Your Ref
AL/75/14/OUT
Our Ref
PLAN-008147
Date
20/11/2014

Proposal: Outline application with some matters reserved for a residential development to the west of the site comprising 2No semi-detached three bed houses and 1No detached two bed bungalow with improved access off hook lane with all other matters reserved.

Site: Woodgate Farm, Westergate Street, Aldingbourne, PO20 3SS.
AL/75/14/OUT

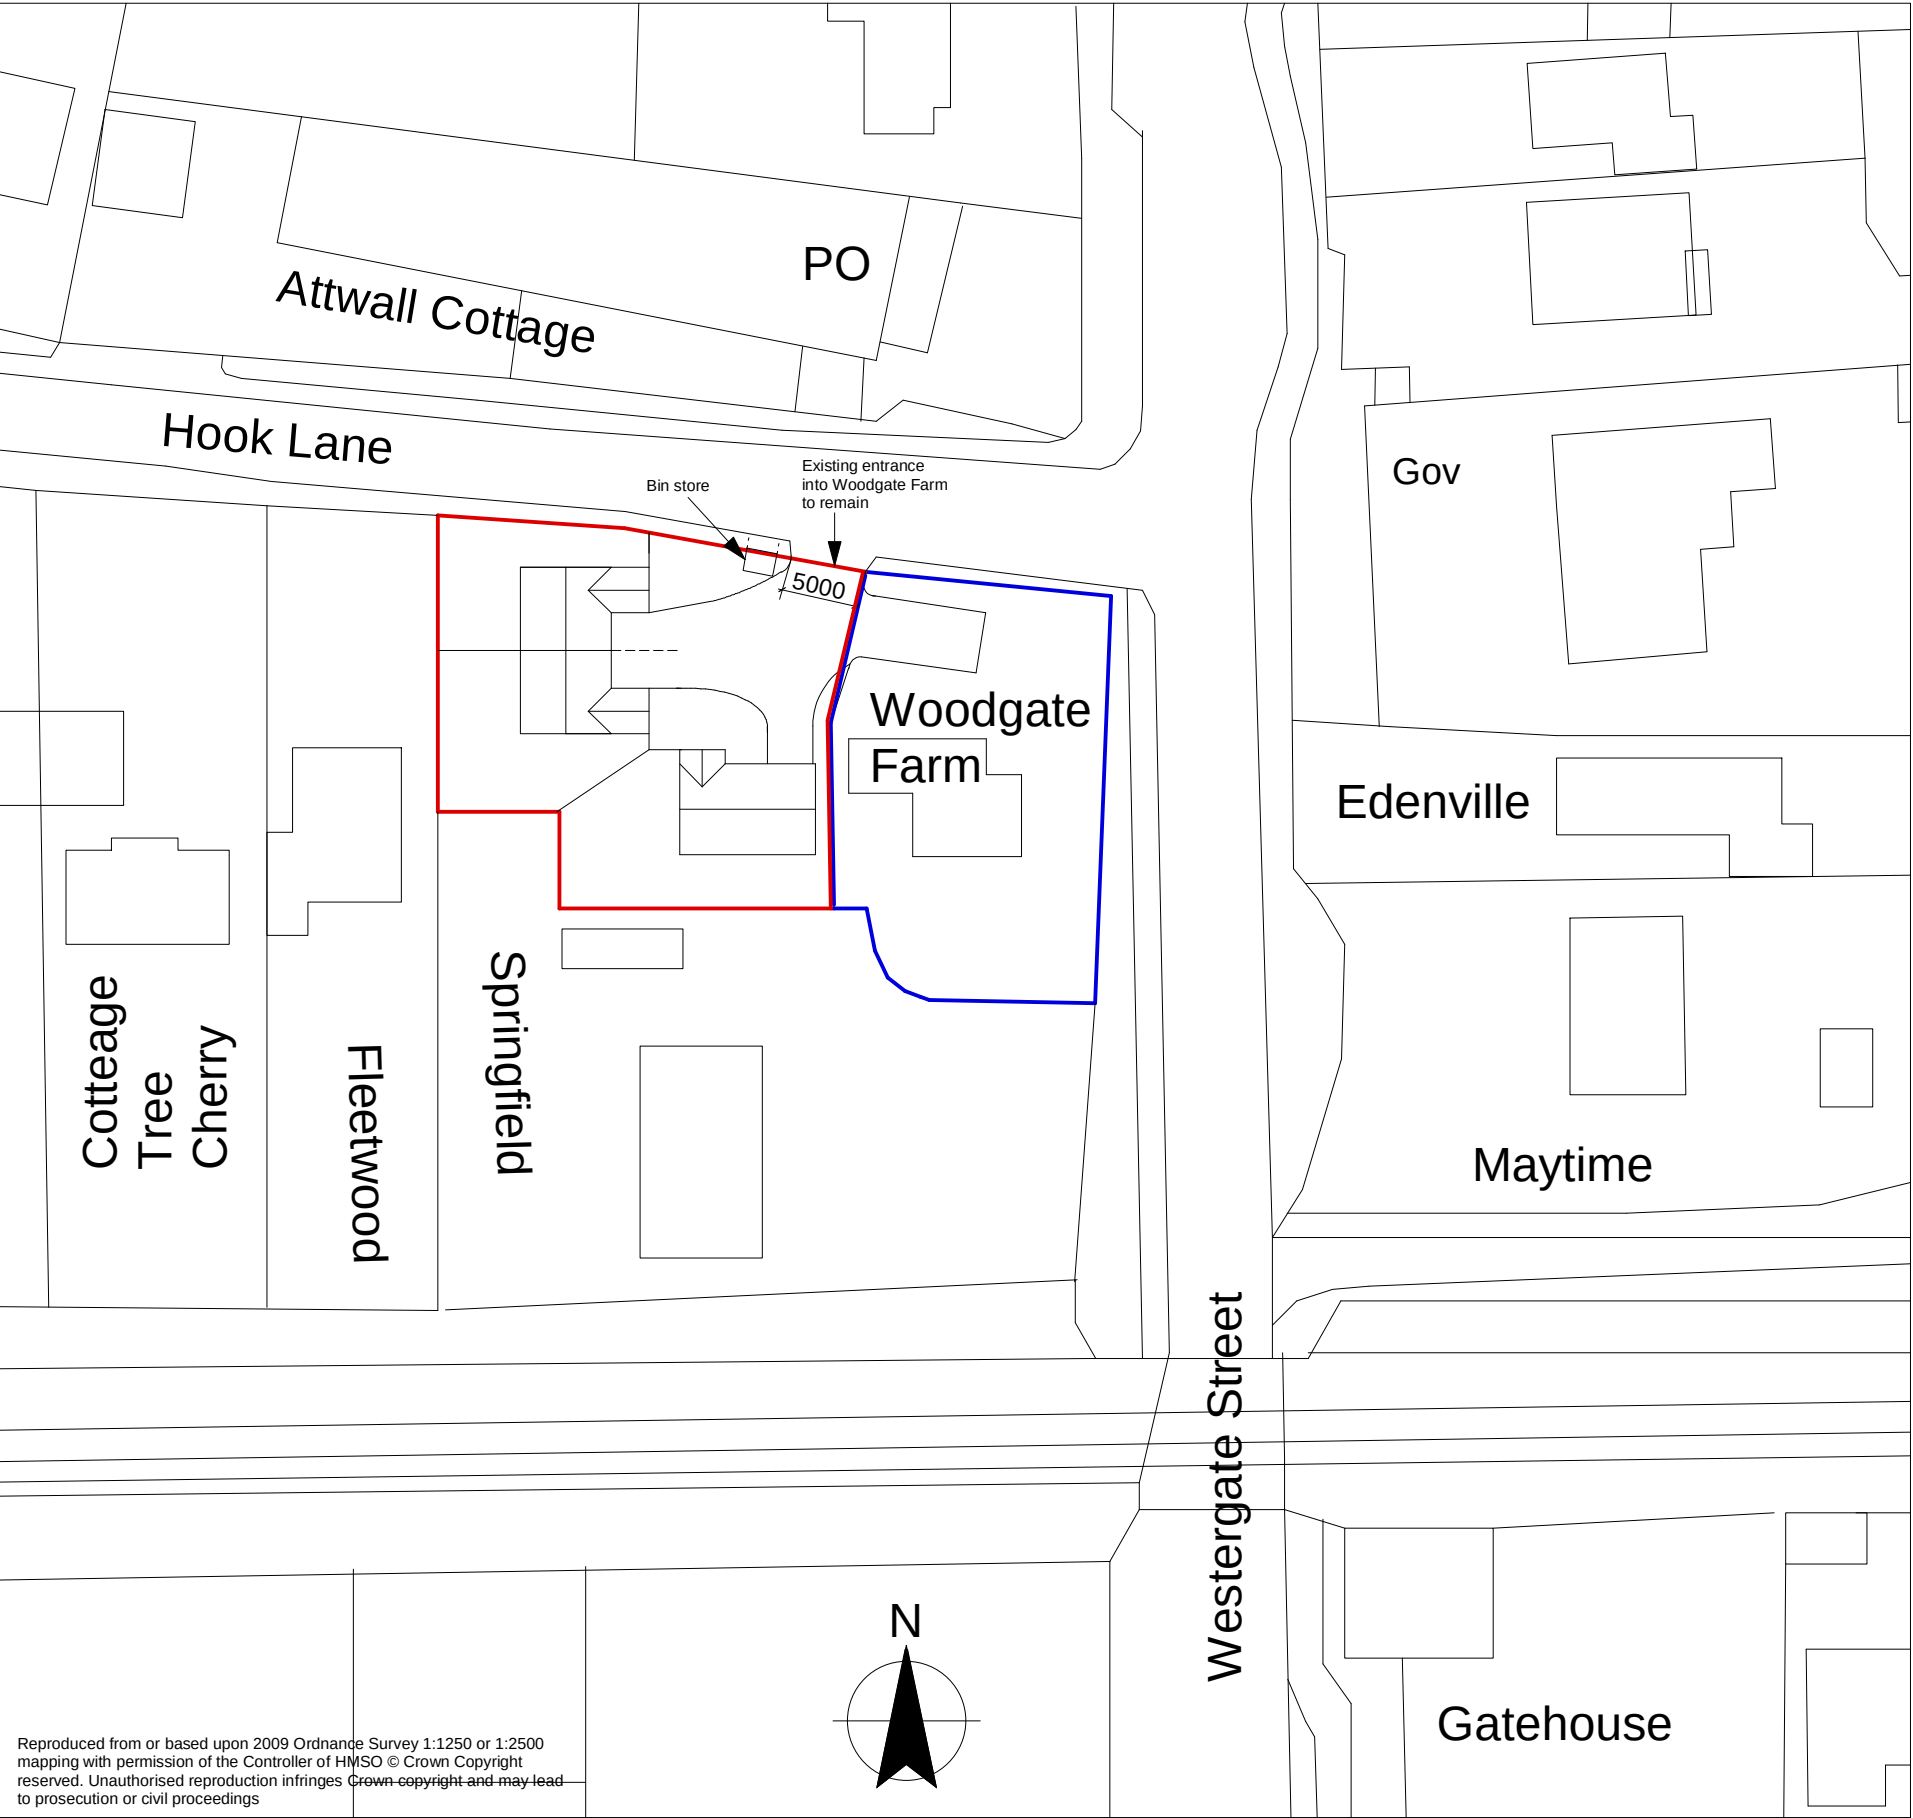
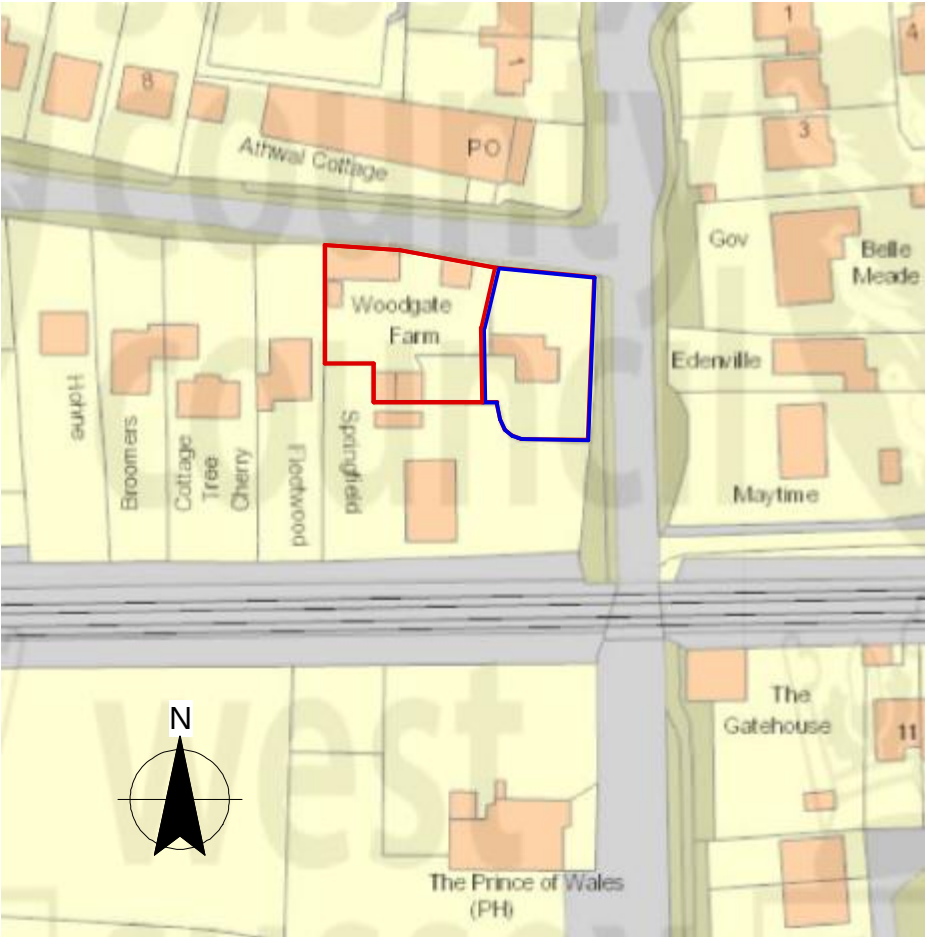
Please find attached a plan of the sewer records showing the approximate position of a public foul sewer crossing the site. The exact position of the public sewers must be determined on site by the applicant before the layout of the proposed development is finalised.

It might be possible to divert the public sewer, so long as this would result in no unacceptable loss of hydraulic capacity, and the work was carried out at the developer's expense to the satisfaction of Southern Water under the relevant statutory provisions.

1. The 150 mm diameter sewer requires a clearance of 3 metres either side of the sewer to protect it from construction works and allow for future access for maintenance.
2. No development or new tree planting should be located within 3 metres either side of the centreline of the public sewer
3. No new soakaways should be located within 5 metres of a public sewer.
